40.4883.R2:ZDS

27<sup>th</sup> October, 2010

**REVIEW OF GDH COMPLIANCE NOISE MONITORING**  
**SOUTHERN HIGHLANDS REGIONAL SHOOTING COMPLEX**  
**WATTLE RIDGE ROAD, HILL TOP**

The purpose of this report is to present the results and findings of a review of a Compliance Noise Monitoring report (dated June 2010) prepared by GHD in relation to noise emission from the Southern Highlands Regional Shooting Complex at Hill Top.

Figure 4: Gunfire Noise Levels Measured at Residential Location A4

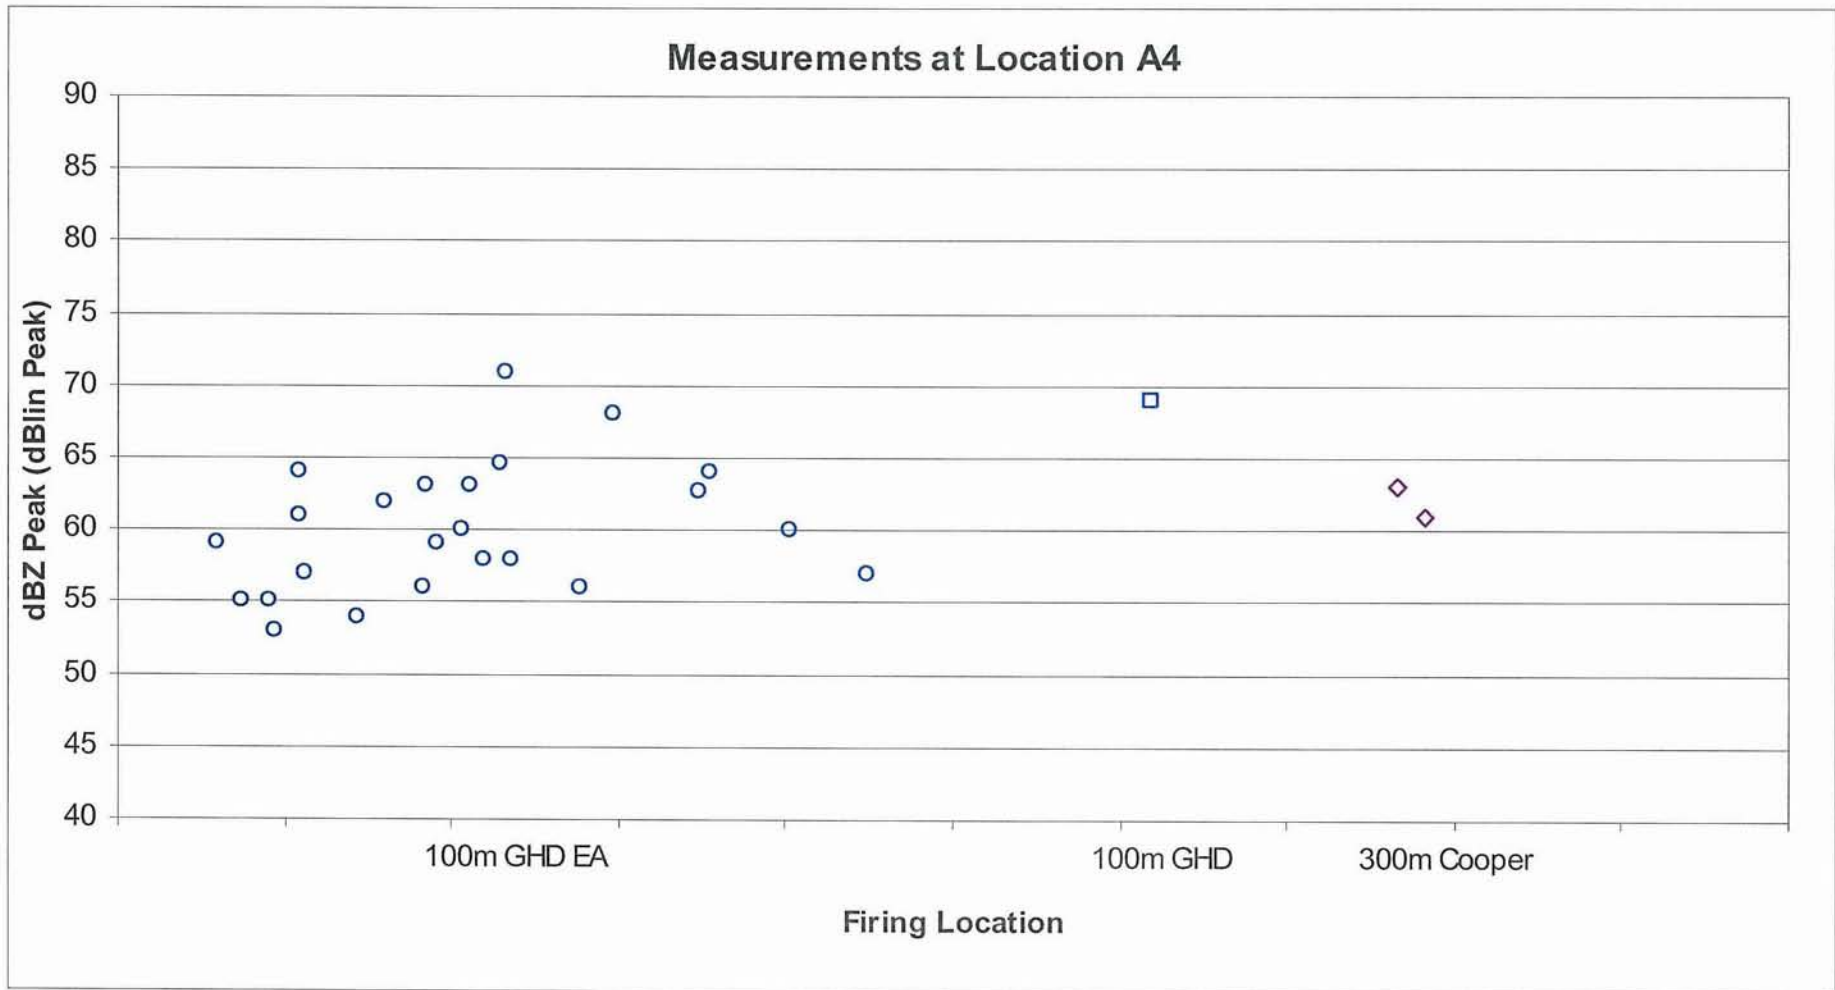
Section 2 of the compliance report identifies four monitoring locations that were used and would appear to accord to an accessible location with respect to residential properties for locations A1, A2 and A3, although with respect to location A4 as identified in the report the location is approximately 600m from the dwelling and therefore being closer to the range is likely to have a higher noise level than that that would be received at the residential location.
